# SSD 16\_7539: DARLINGTON TERRACES MIXED USE DEVELOPMENT

## THE UNIVERSITY OF SYDNEY, DARLINGTON CAMPUS

### AMENDMENT TO THE PROPOSAL

### RESPONSE TO SUBMISSIONS

0 2,000 4,000 8,000 16,000 m

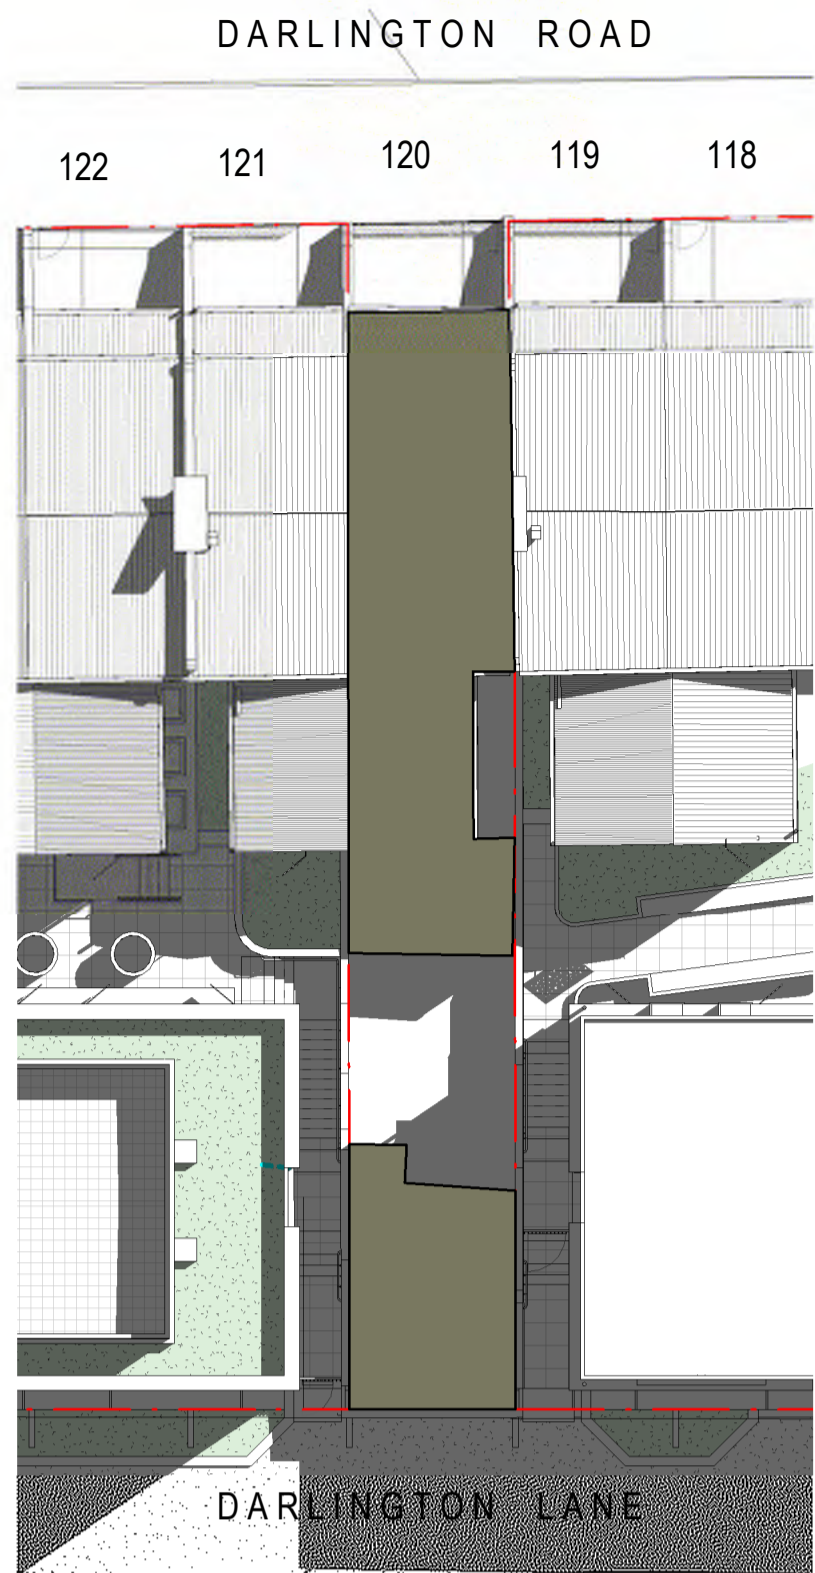
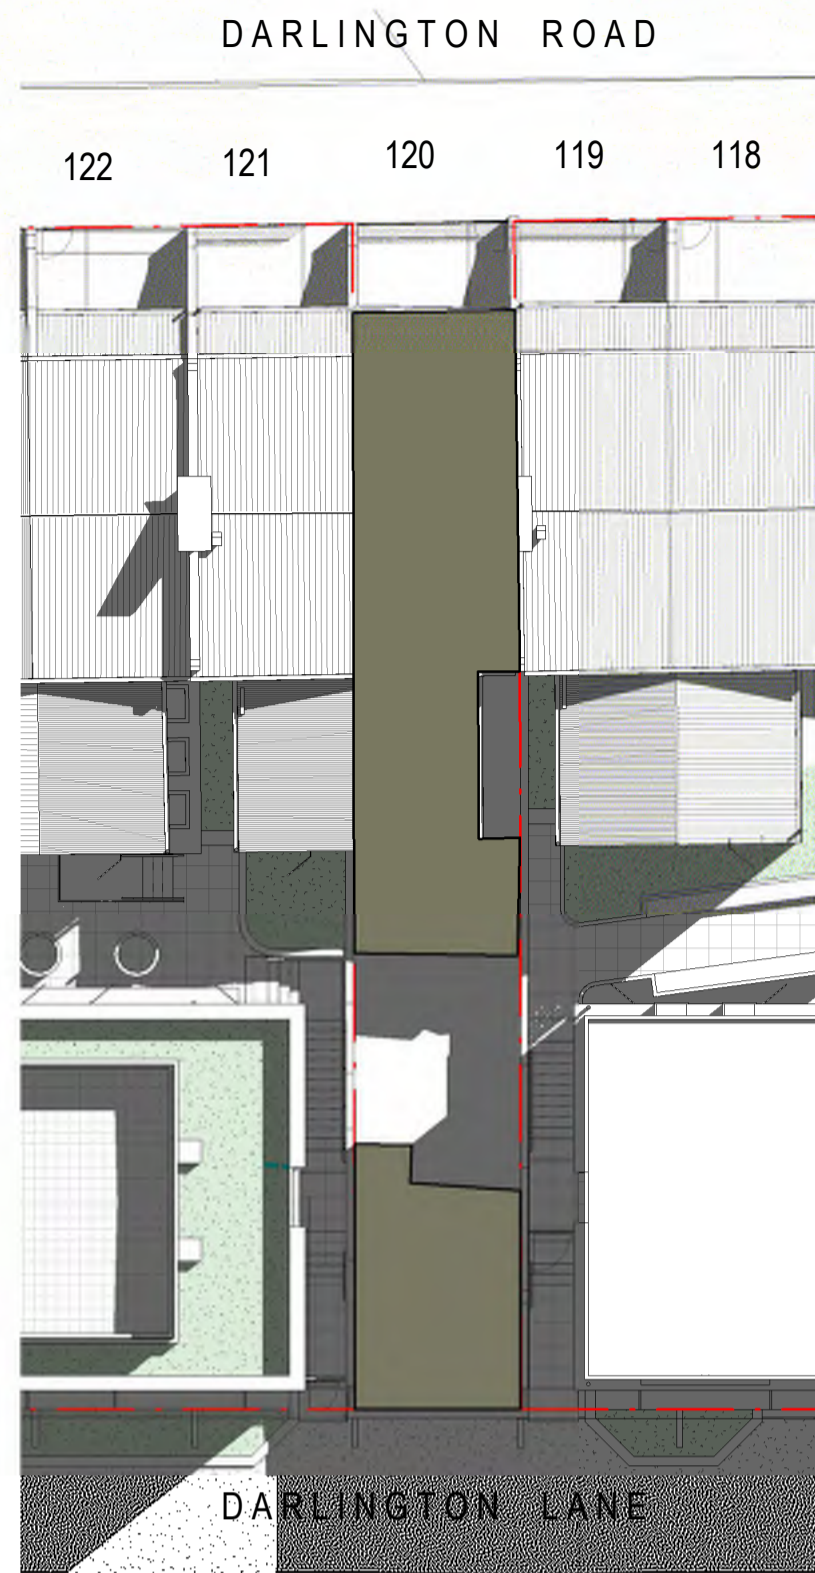
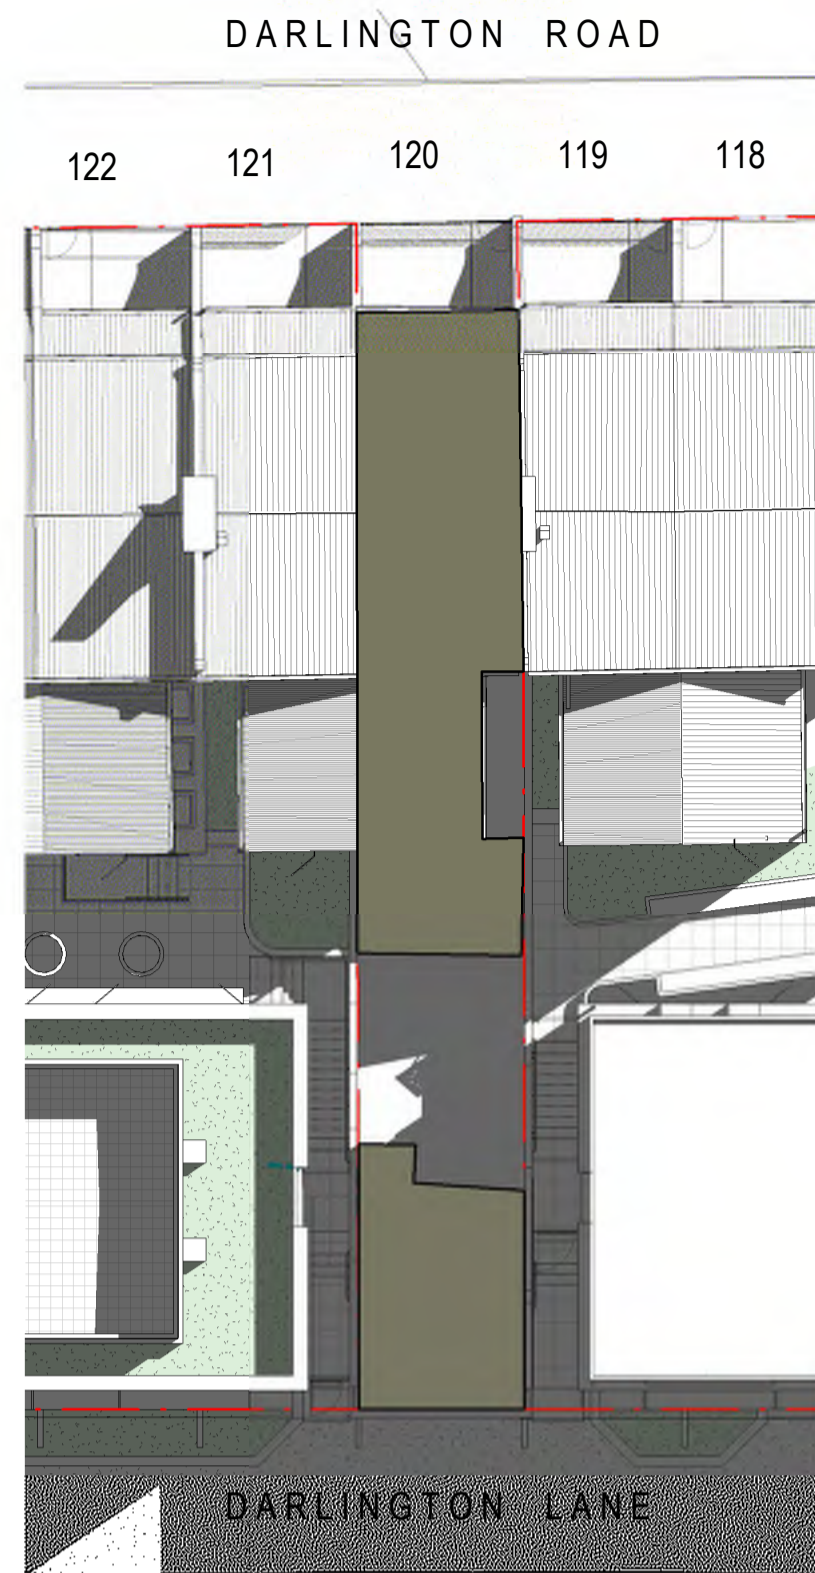
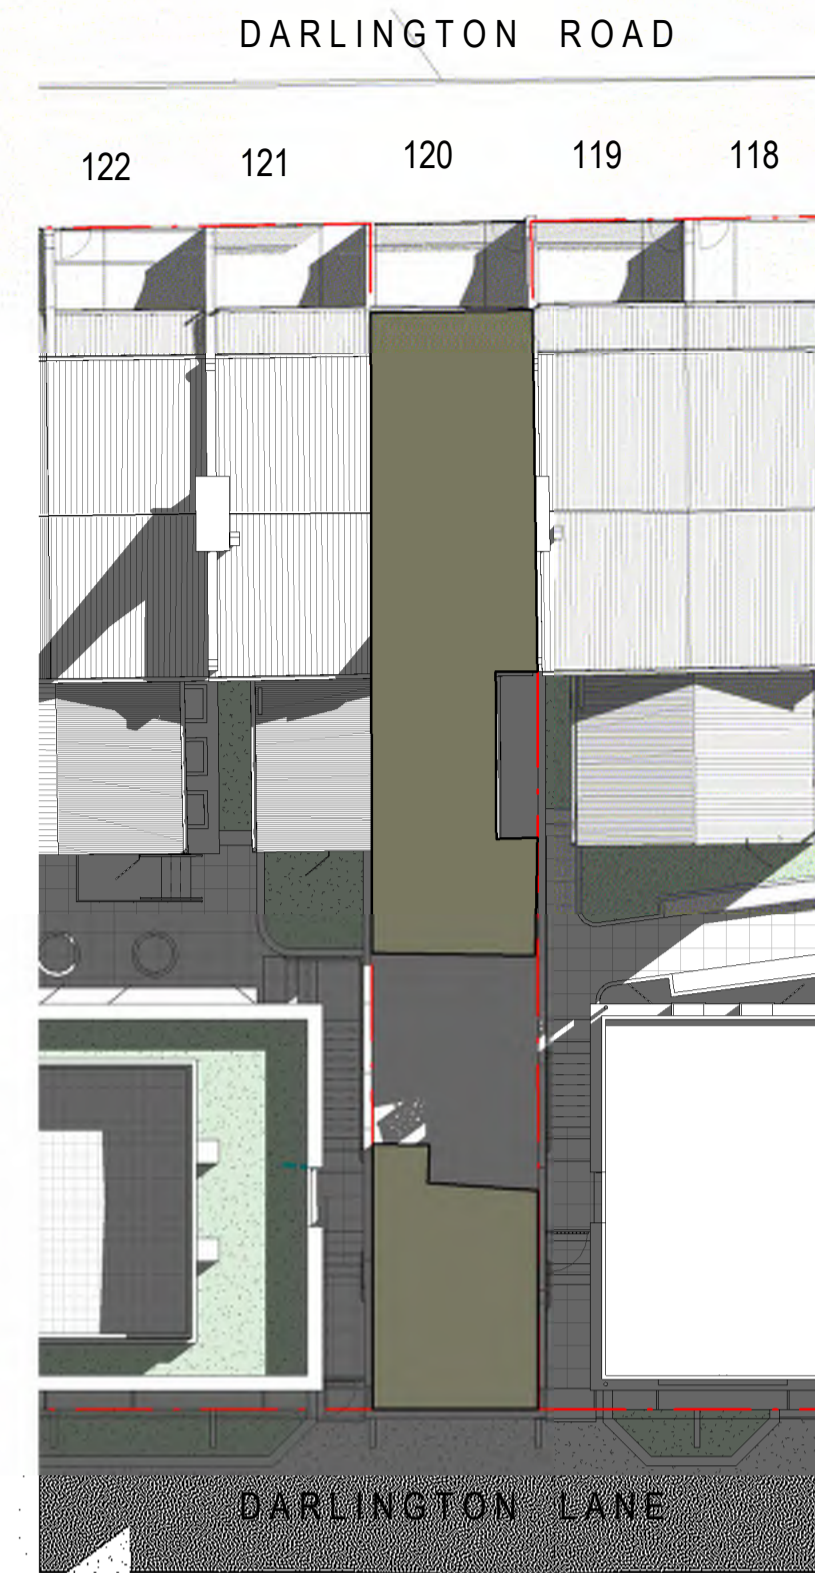
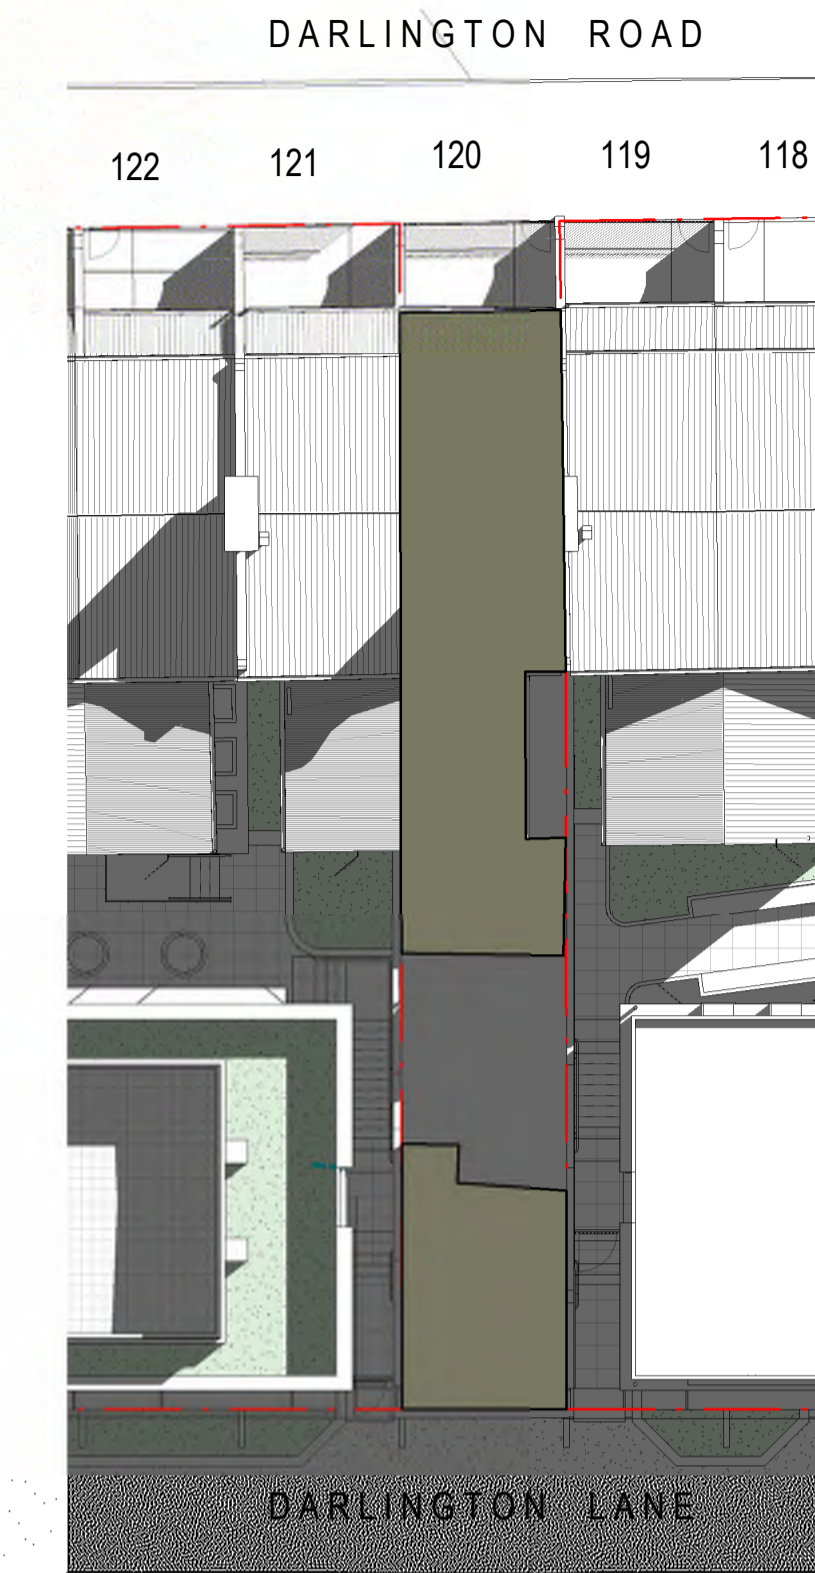
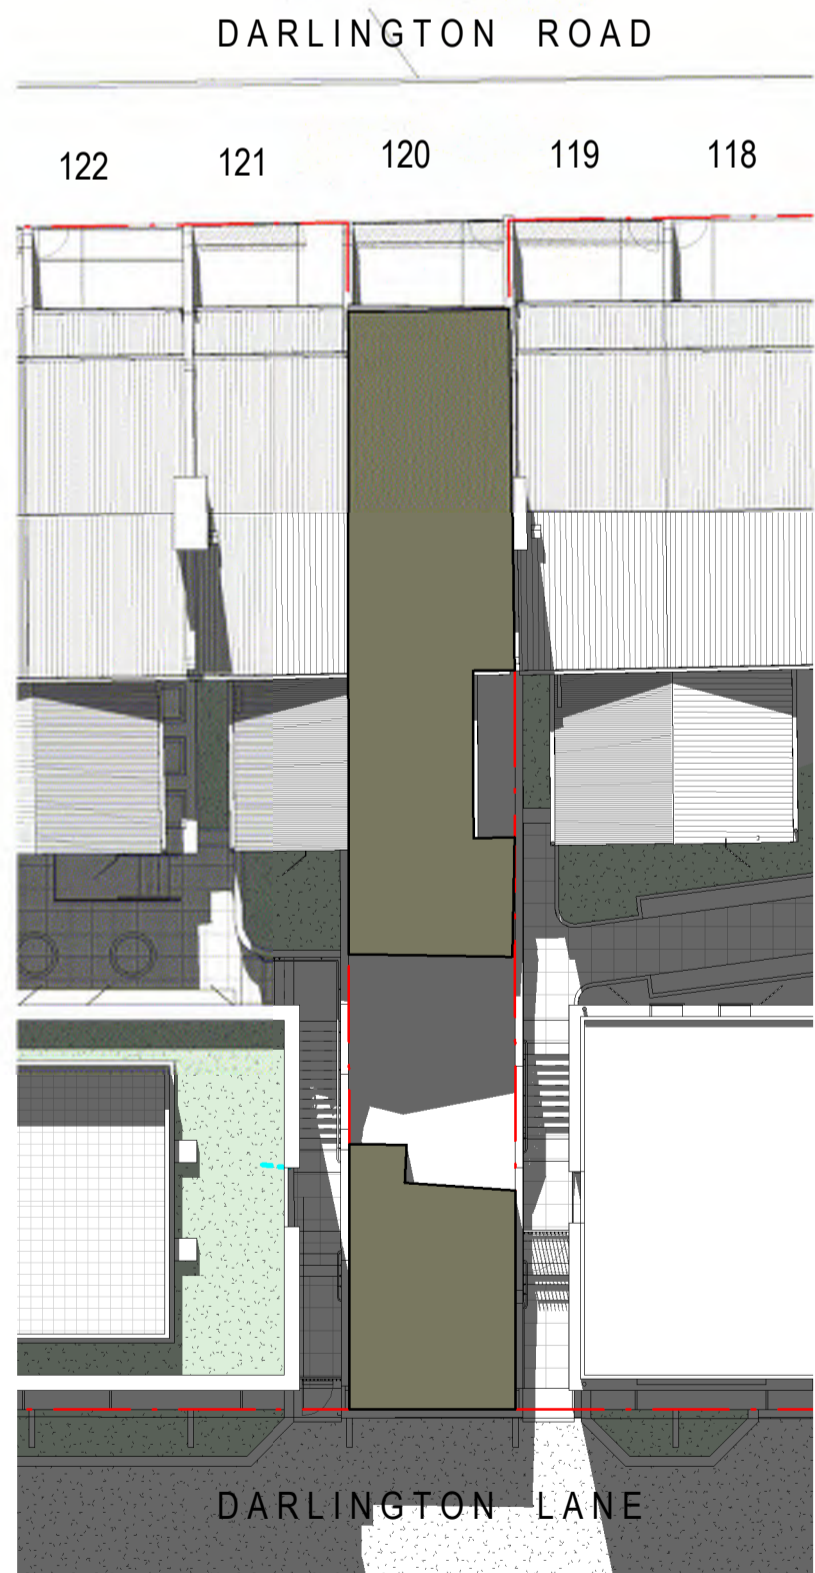
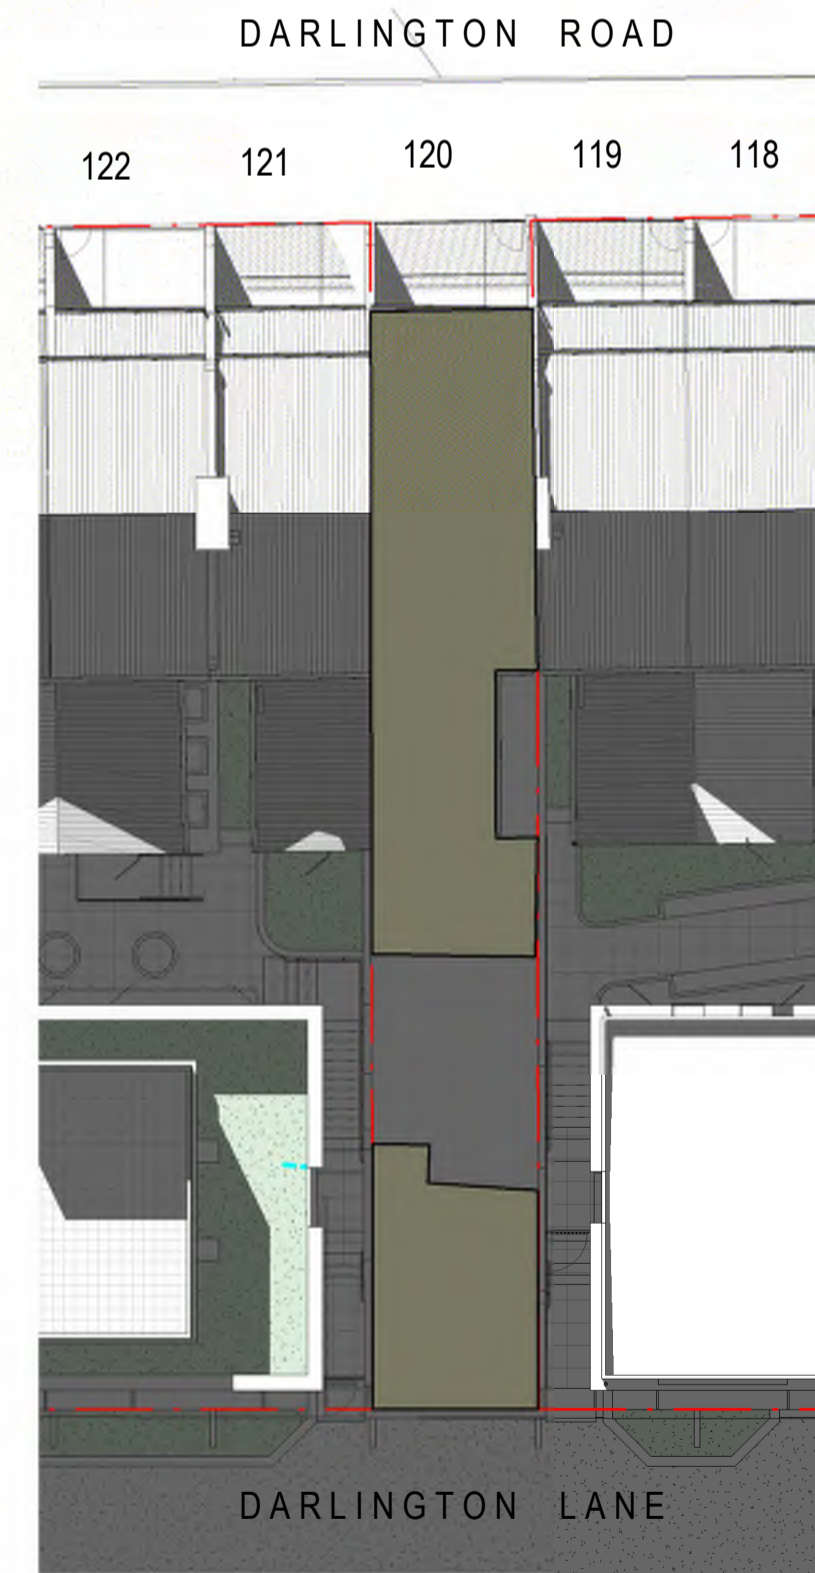
<p><b>Residential Amenity</b></p> <p>3. The overshadowing analysis must illustrate that adequate solar access has been maintained to the adjoining private residential properties and additional overshadowing from the proposal does not result affected properties retaining less than a minimum two hours of solar access to 50 per cent of the private open space areas between 9 am and 3 pm on 21 June. Additional shadow diagrams illustrating overshadowing at hourly intervals (at a minimum) must be provided to clearly demonstrate impacts on open space areas of the private residential properties affected by the proposal.</p>	<p><b>Agreed:</b> The amended Shadow Analysis by project architects AJ+C are addressed in the package of Architectural Plans (<b>Appendix A-3</b>). The two privately owned Terraces located in between the proposed new buildings are No’s 120 and 97 Darlington Road and the Shadow impacts to the rear yards of these Terraces are addressed at <b>Appendix A-4</b>.</p> <p>The AJ+C Shadow Analysis confirms that:</p> <ul style="list-style-type: none"> <li>• No. 120 Darlington Road currently receives less than 2 hours sunlight to 50% of open space, and will not receive any additional shadows to the rear yard of the property because of the proposed development; and</li> <li>• No. 97 Darlington Road currently receives less than 2 hours sunlight to 50% of open space. The design of new Building Block D, immediately to the east of and adjoining 97 Darlington Road, has been modified by including a splayed treatment at its north-western corner, in order to avoid any additional overshadowing and thereby ensure that current levels of solar access to the rear yard of (private) 97 Darlington Street are maintained as existing.</li> </ul>

SSD 16_7539 – DARLINGTON TERRACES MIXED USE DEVELOPMENT	
DPIE KEY ISSUE	UNIVERSITY PROJECT RESPONSE
	<p>The AJ+C shadow analysis at <b>Appendix A</b> also includes an hour-by-hour birds eye view of solar access which demonstrates that compliant levels of solar access will be provided to the north facing elevations of the new Darlington Terraces. Solar access to the street front facades of the original Darlington Terraces fronting Darlington Road will remain unaltered.</p>
<p>4. Further <b>Shadow Impacts</b> upon (private) 120 Darlington Road:</p> <ul style="list-style-type: none"> <li>• DPIE acknowledges no mid-winter shadow impacts or any solar reception.</li> <li>• DPIE request an assessment of solar impacts at other times of the year to ascertain what solar access 120 Darlington will receive for min 8sq.m. for period of 2 hours.</li> <li>• If the above-mentioned solar access cannot be received, then USYD to consider built form amendment.</li> <li>• Seek commentary on built form compliance with CIP for solar access.</li> </ul>	<p><b>Agreed:</b> Additional Solar Access Plans (Dwgs DA3910 - DA3913) have been prepared by AJ+C and are found at <b>Appendix A-3</b> (overall mid-winter analysis) and <b>Appendix A-4</b> (for 120 Darlington Road).</p> <p>An analysis of the overshadowing impact of the SSD proposal to the privately owned property at 120 Darlington Road has been conducted on the 1<sup>st</sup> and 15<sup>th</sup> day of each month, and concludes:</p> <ul style="list-style-type: none"> <li>• From 01 January – 01 May (4 months) No.120 Darlington Road will receive 2 hours and above of sunlight to at least 8m<sup>2</sup> of its rear private open space (southern aspect). The property will <b>also</b> receive at least 2 hours and above sunlight to at least 8m<sup>2</sup> of its front private open space facing Darlington Road (northern aspect).</li> <li>• From 01 May – 01 September (4 months) No.120 Darlington Road will receive 2 hours and above of sunlight to at least 8m<sup>2</sup> of its front private open space facing Darlington Road (northern aspect).</li> <li>• From 01 September – 01 January (4 months) No.120 Darlington Road will receive 2 hours and above of sunlight to at least 8m<sup>2</sup> of its rear private open space (southern aspect). The property will <b>also</b> receive at least 2 hours and above of sunlight to at least 8m<sup>2</sup> of its front private open space facing Darlington Road (northern aspect).</li> </ul> <p>✓ In summary, N°.120 Darlington Road will receive at least 2 hours of sun to at least 8m<sup>2</sup> of private open space all year round and will therefore more than satisfy the objectives of <i>Sydney DCP 2012</i> clause 4.1.3.1 <i>Solar Access</i>.</p> <p>✓ Notwithstanding the solar access compliance described above, the University confirms that the built form of the rear Darlington Terraces additions complies with the maximum building envelopes approved by the CIP – SSD 13_61123 (refer to AJ+C elevations for plans to illustrate building envelope compliance at <b>Appendix A-2</b>).</p>
